August 2, 2018

SH 24A
El Paso County

RE: PPR1828/AL1810 - Ute Pass Mini Storage; Parcels; 8315300029 and 831530025

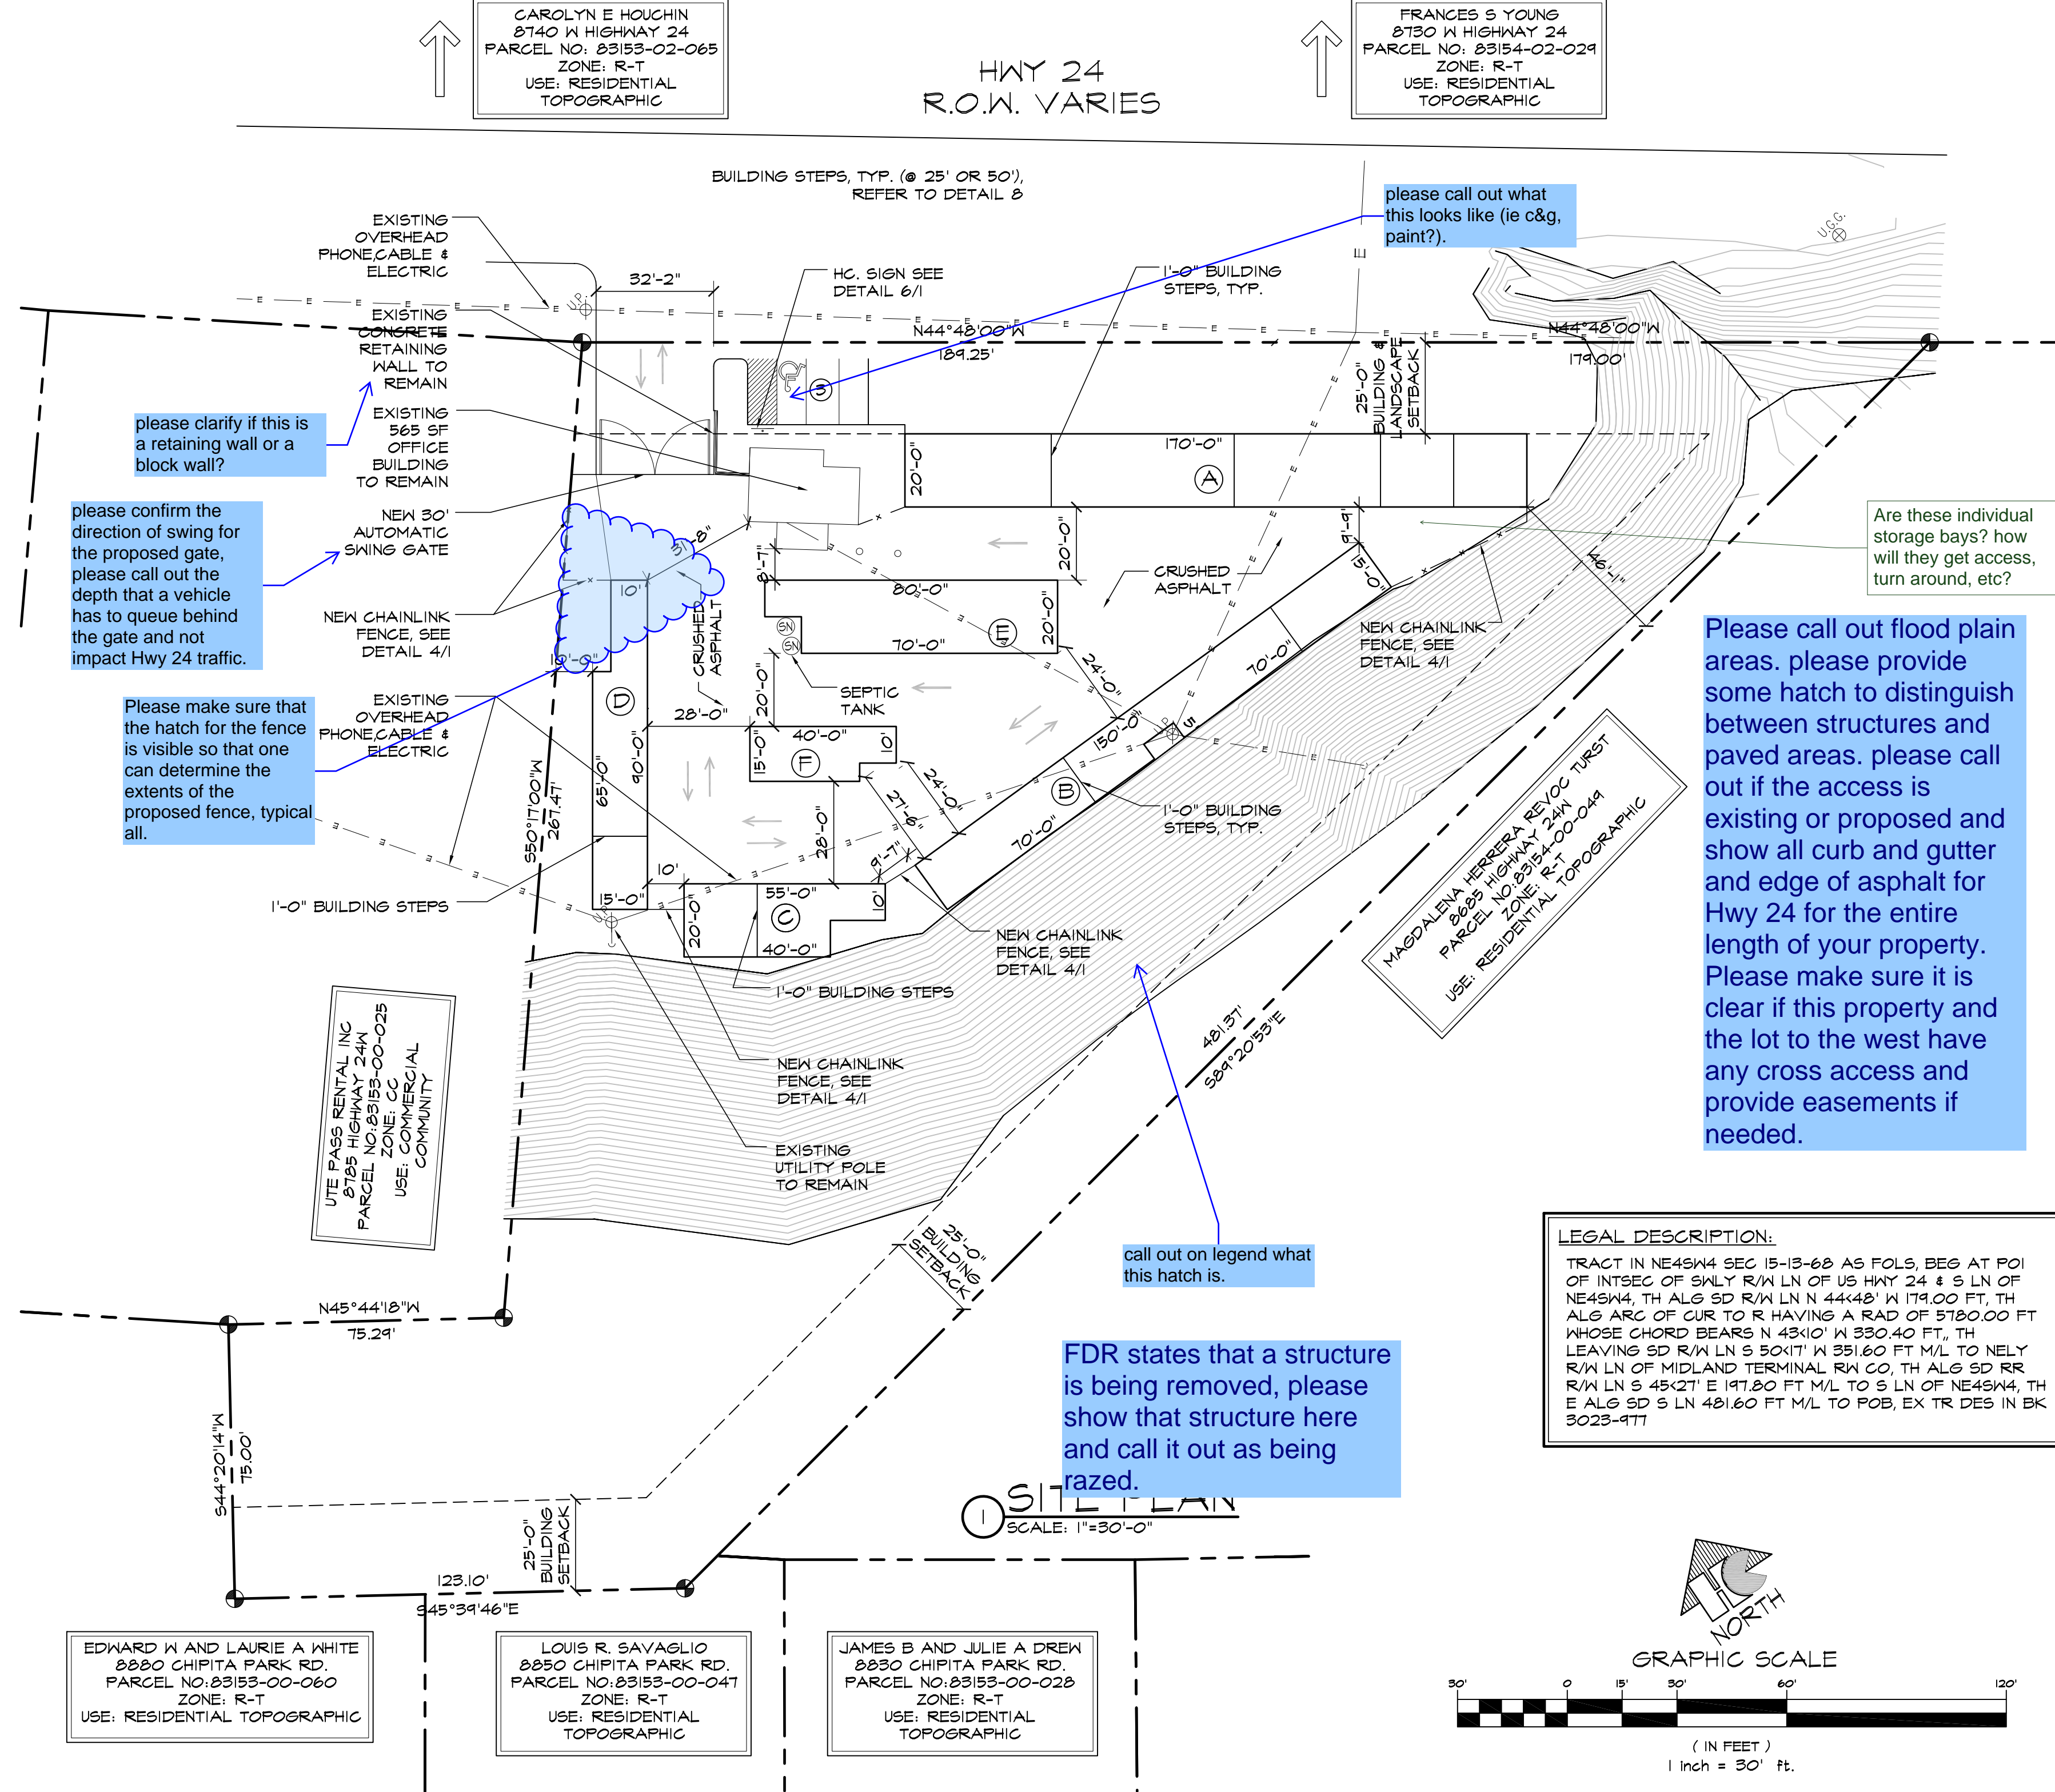
- The Hammers Construction, Inc. site map/parking plan has been reviewed and the Department requests the following:
 - Define the property line in relation to State Highway right-of-way. Currently, the Hammers Construction Inc. plan depicts, "Hwy 24 R.O.W. Varies"
LSC Response (8-27-18): Attached LSC Exhibit shows south ROW line and width of ROW (approx.).

- State Highway law does not allow for vehicles to back into State Highway right-of-way, please provide a parking plan that depicts this.
LSC Response (8-27-18): Attached LSC Exhibit includes a parking plan.
